From: Martyn White
Sent: 20 November 2018 10:13
To: Anita Gardner
Subject: CM/26/18/L

CM/26/18/L

The application seeks to undertake sympathetic works to the roof of the Mill. Further it also proposes to undertaken a small section of rebuilding to the northern gable to enable roof to be reinstated over exposed verges; as well as specific repointing where brickwork is defective; repointing of chimney stacks using the correct mortar.

Project Name: The Mill Buildings Climping	
Drawing No. 7	Drawing Title: Existing Mill Buildings Elevations
Date: 11/12/2017	
Scale: 1:100 @A1

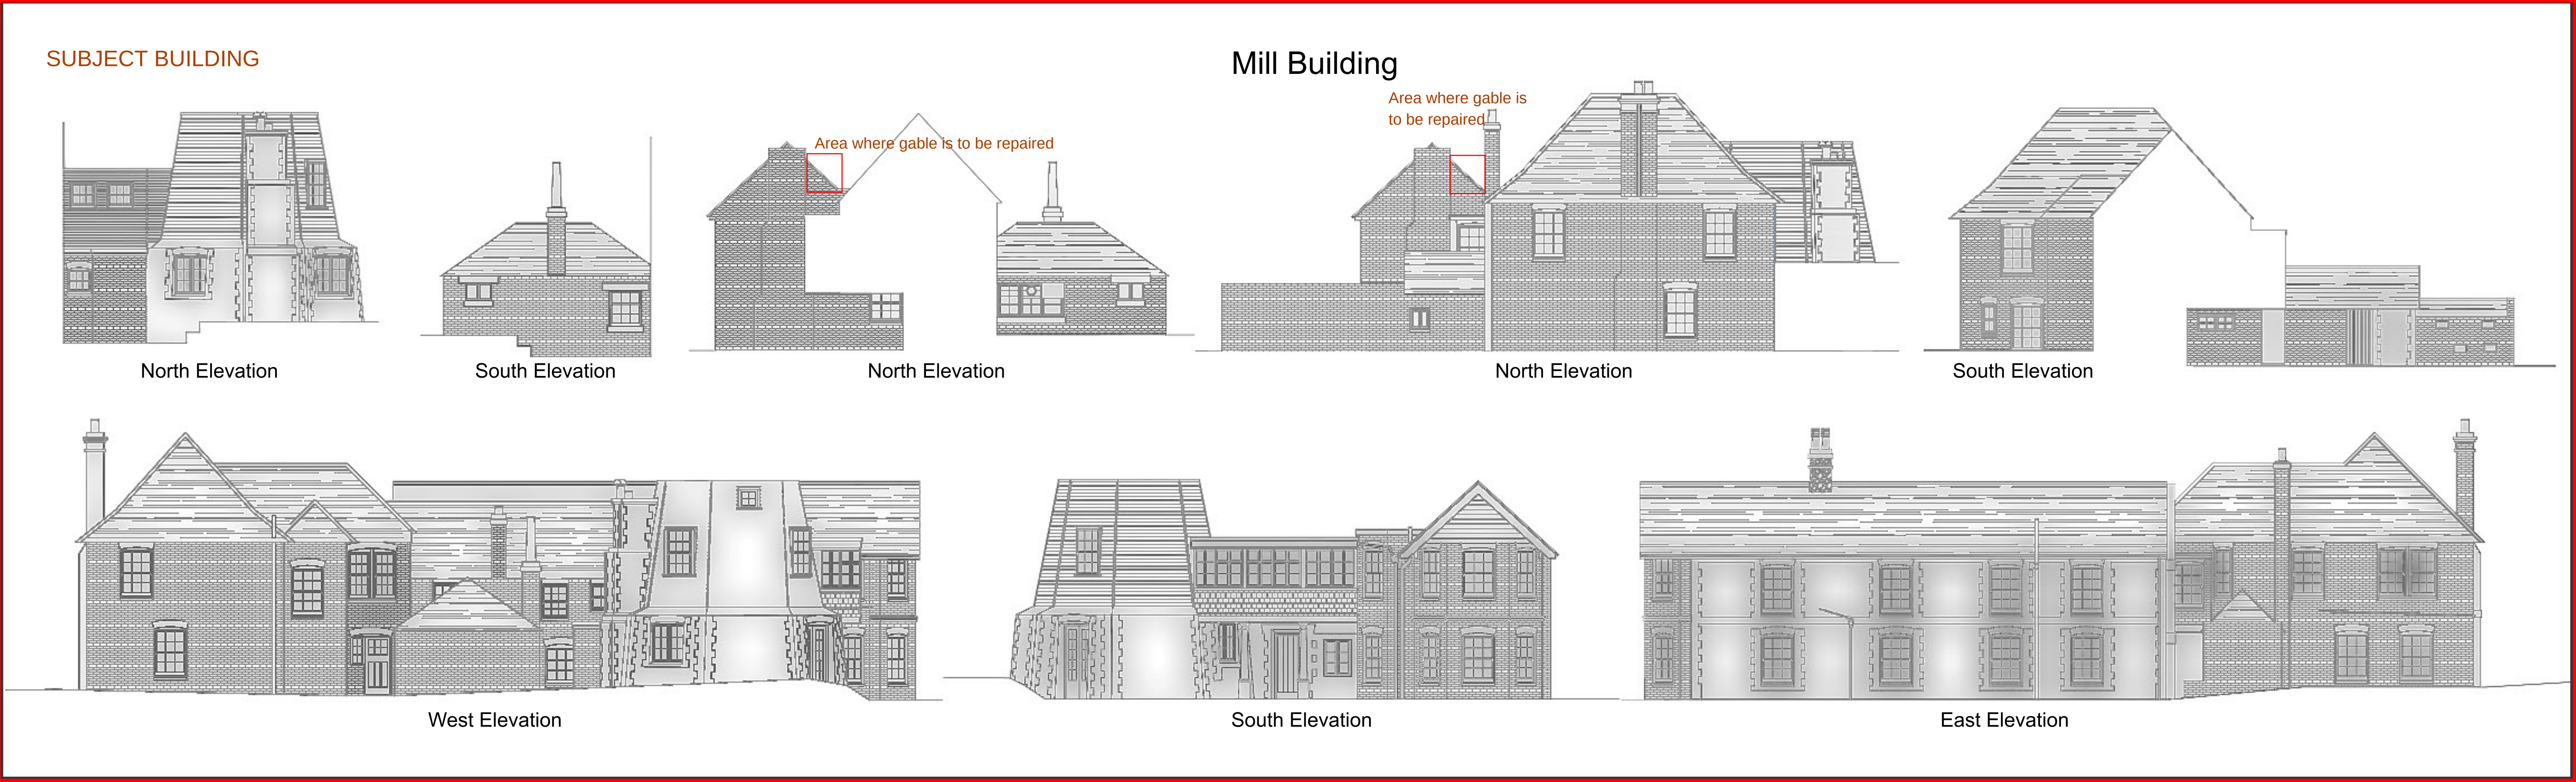
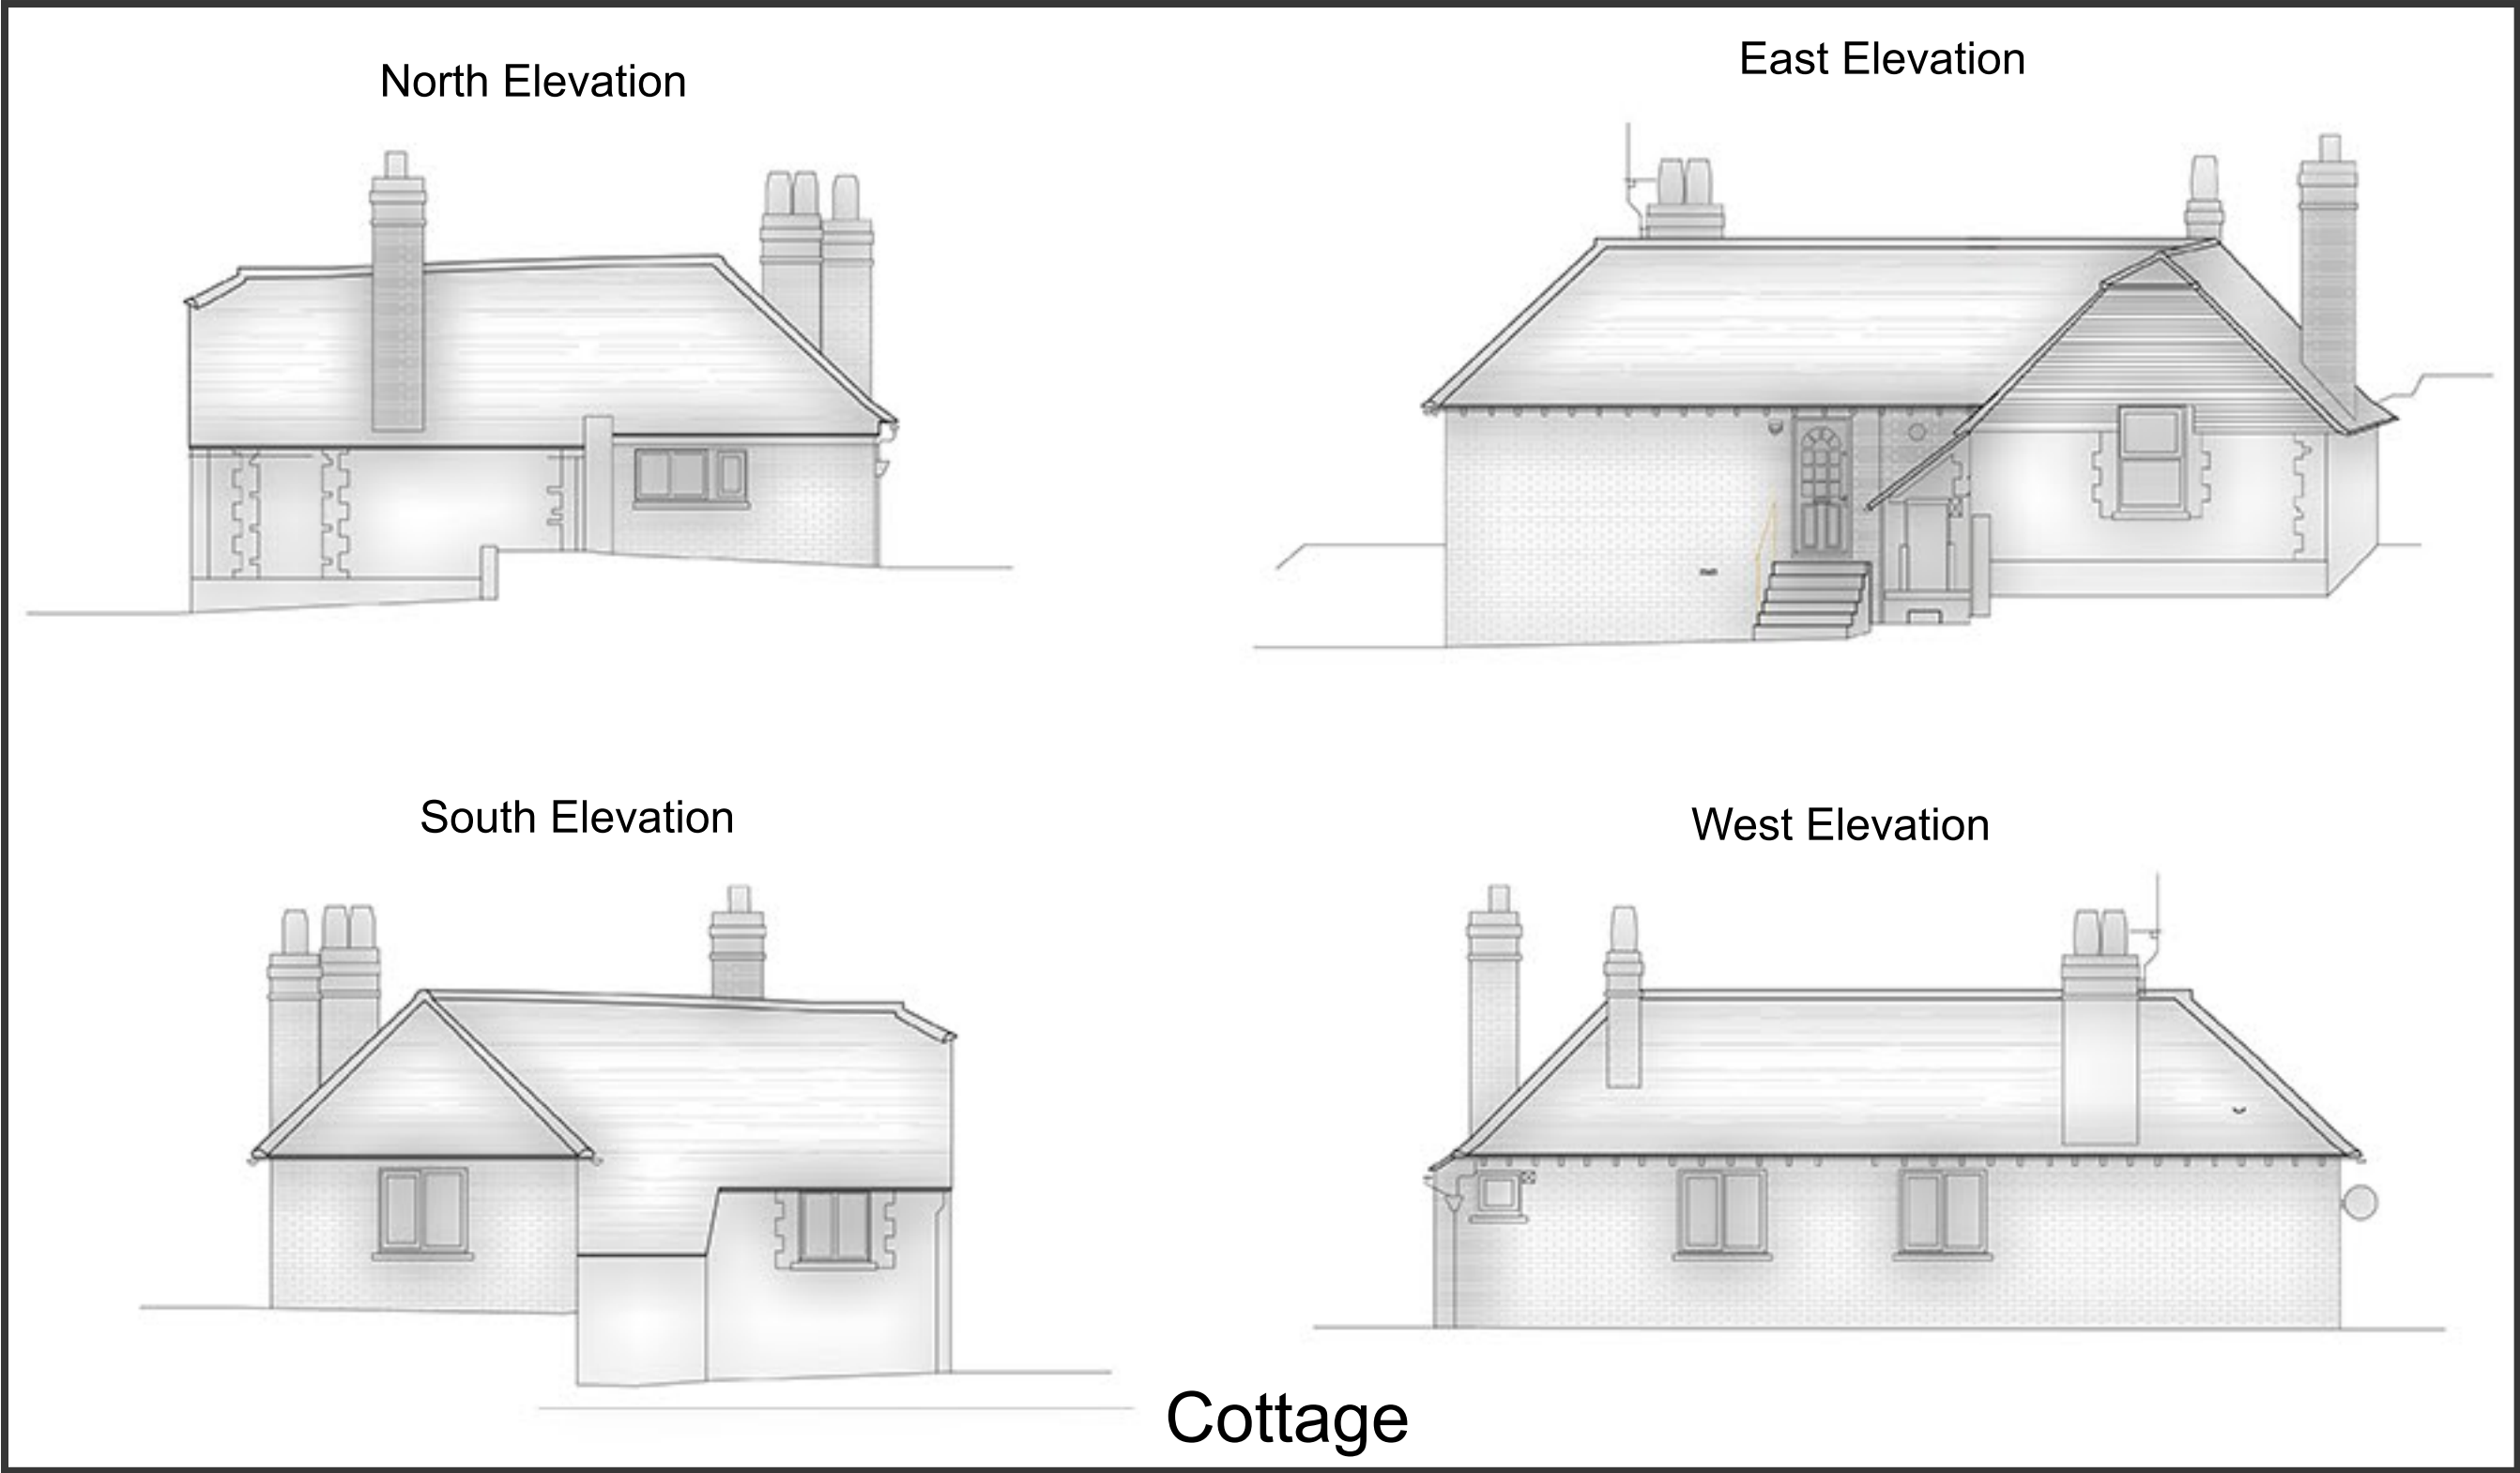
You may wish to condition the details of the slate/clay tile, along with the replacement rainwater goods, and details of the works to the northern gable which will extend the roof to cover the exposed flint wall.
